WEST SUSSEX COUNTY COUNCIL CONSULTATION

TO:	Arun District Council - FAO: Simon Davis
FROM:	WSCC - Highways Authority
DATE:	27 May 2021
LOCATION:	Land Rear Of 1 Northfields Cottages, Fontwell Avenue, Eastergate, PO20 3RX
SUBJECT:	BN/54/21/DOC Approval of details reserved by condition imposed under ref BN/50/20/PL relating to Condition Nos 5 - mitigation method statement, 6 - archaeology, 7 - piling risk assessment & method statement, 8 - Construction & Environmental Management Plan, 9 - foul drainage, 10 - surface water drainage, 11 - maintenance & management of surface water drainage, 13 - pre-commencement site meeting, 15 - odour assessment or evidence that livery has ceased, 16 - soil resource plan, 17 - landscaping, 18 - screen walls & fences, 19 - elevation details of 2 proposed communal bin stores and 20 - colour schedule of materials & finishes.
RECOMMENDATION:	More Information

West Sussex County Council, in its capacity as Local Highway Authority (LHA), have been consulted on discharge of condition 8 of BN/50/20. Condition 8 pertains to requirement for Construction & Environmental Management Plan (CEMP) for 42 x dwellings on land at Fontwell Avenue. A Construction Phase pl

SITE COMPOUND LAYOUT - EASTERGATE

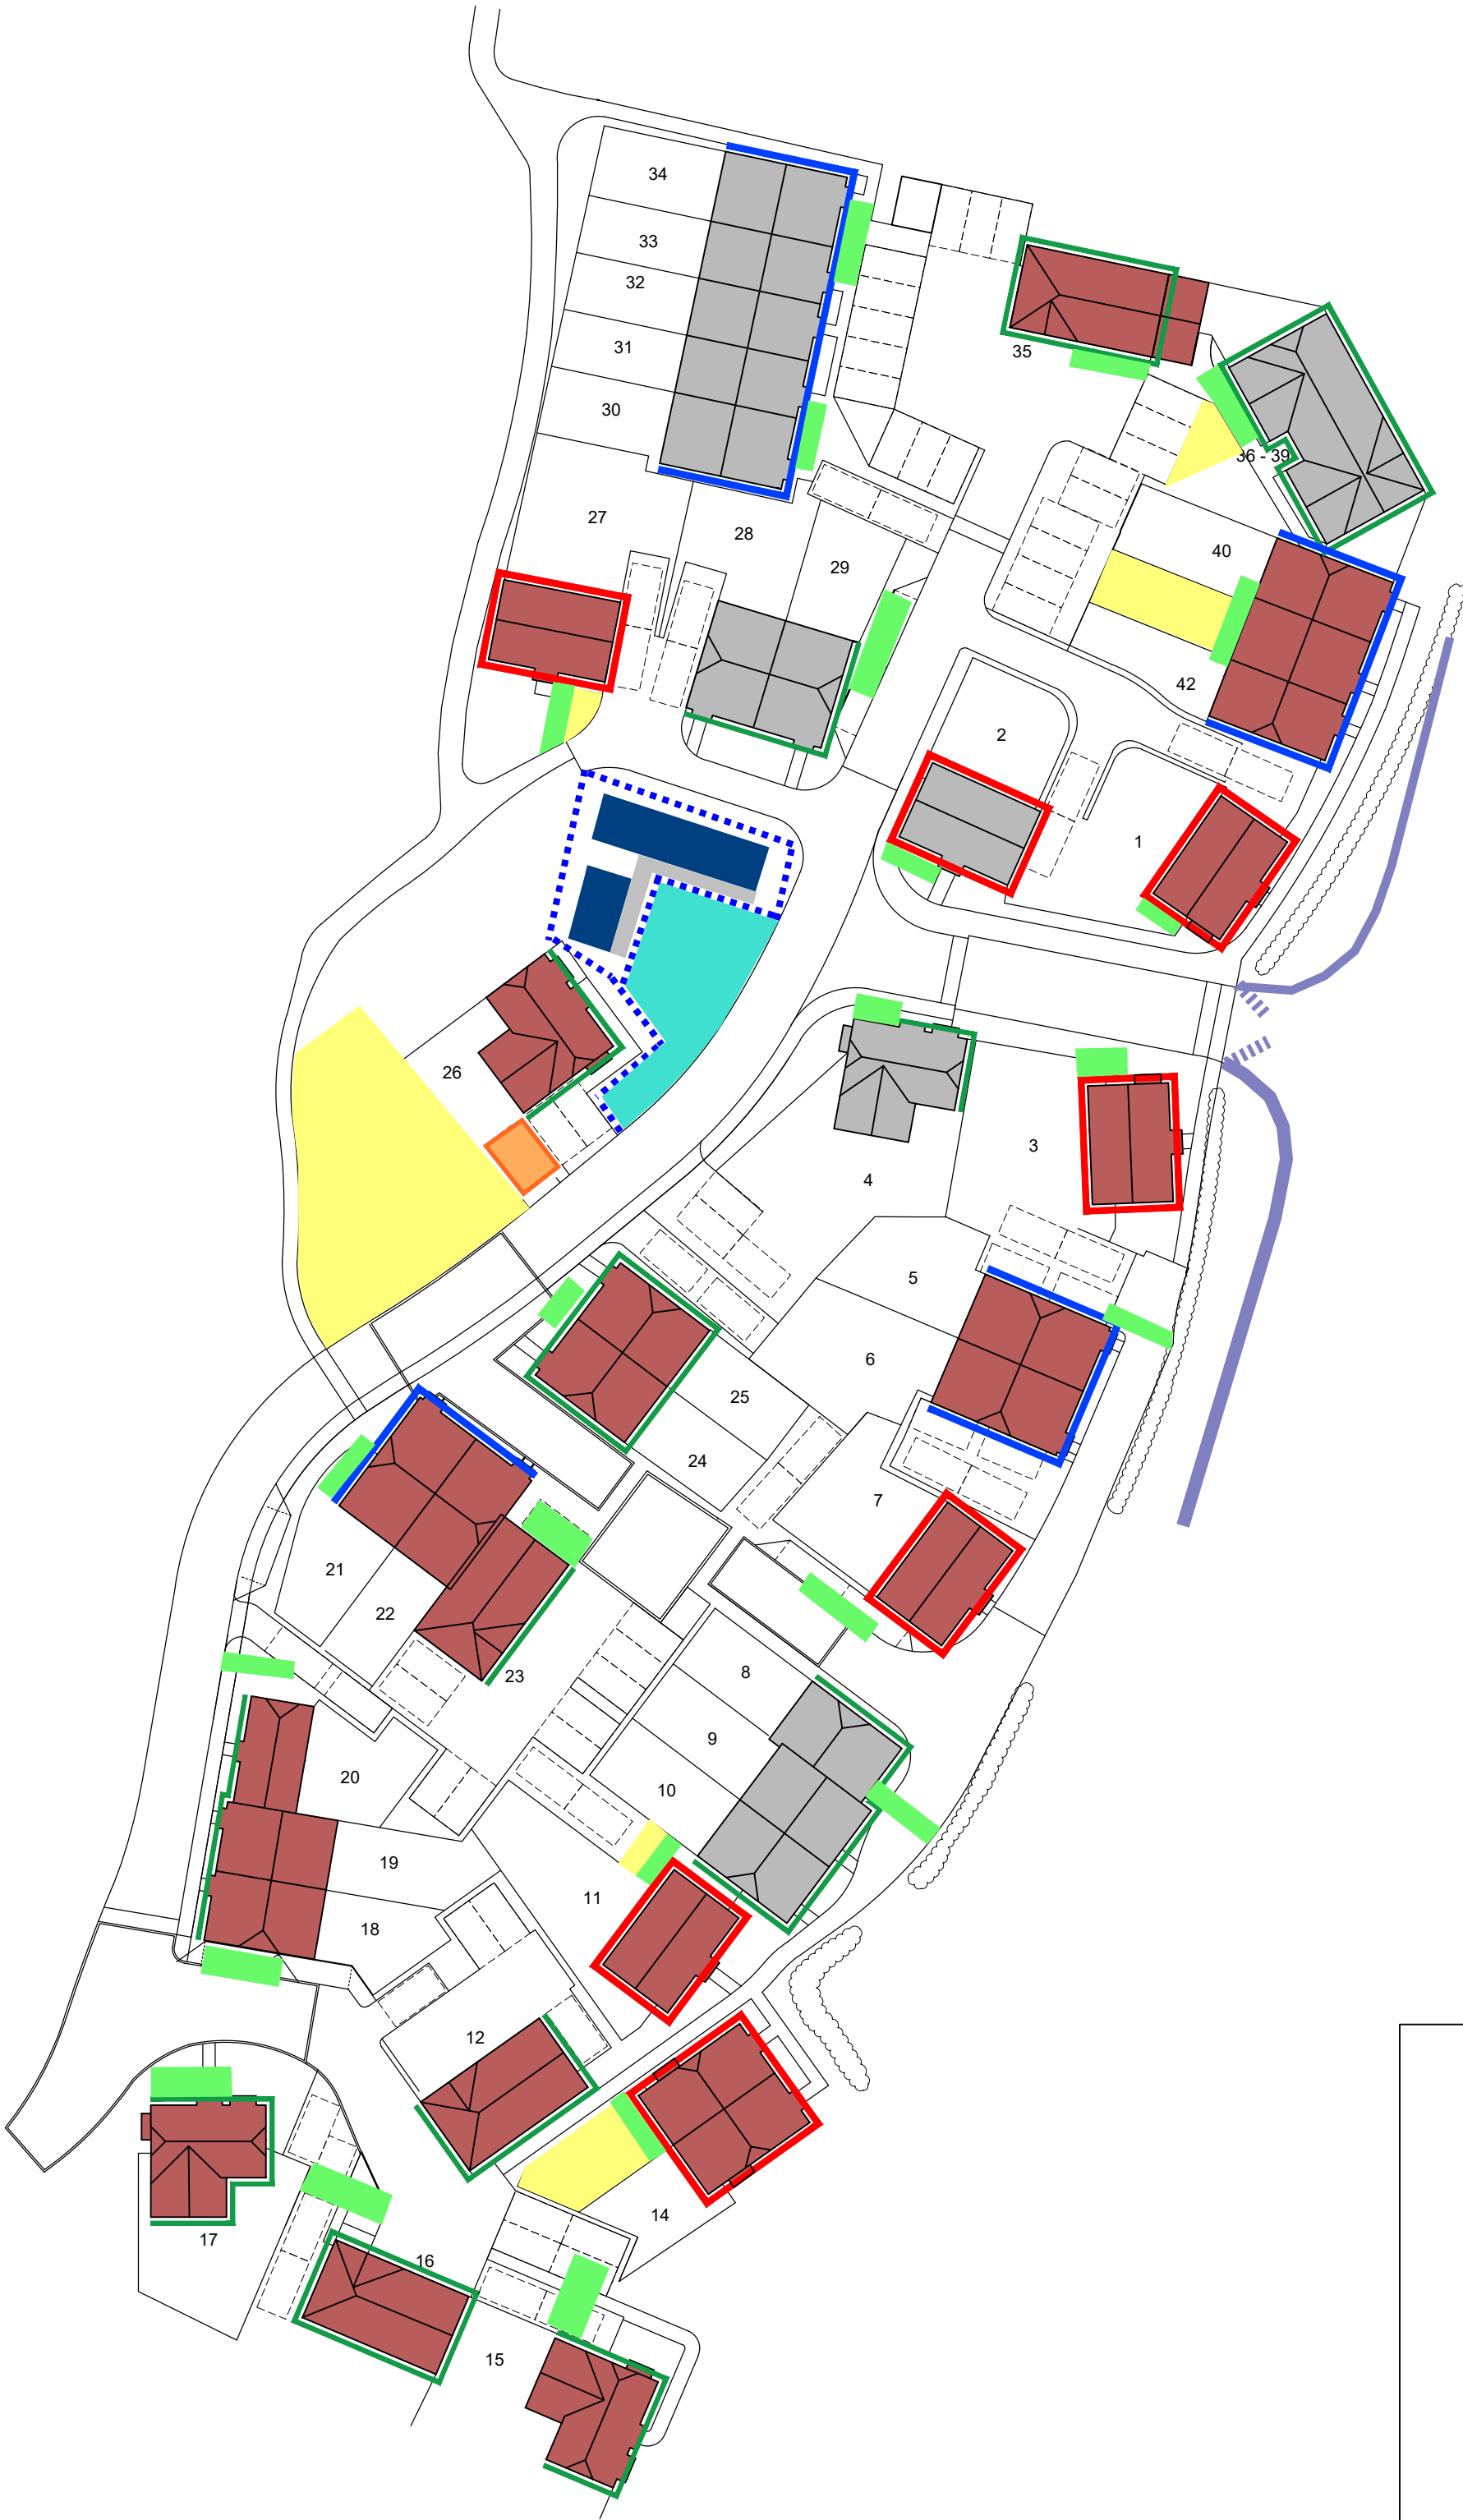
Detailed area for this should be shown on the Site Layout Plan.

Will be within confines of site - pull in area and dedicated unloading point and turning is proposed. Plan detailing this should be provided.

Detailed area for this should be shown on the Site Layout Plan.

Detailed area for this should be shown on the Site Layout Plan.

If required a wheel wash will be set up at site exit, advise this is shown on the plan.
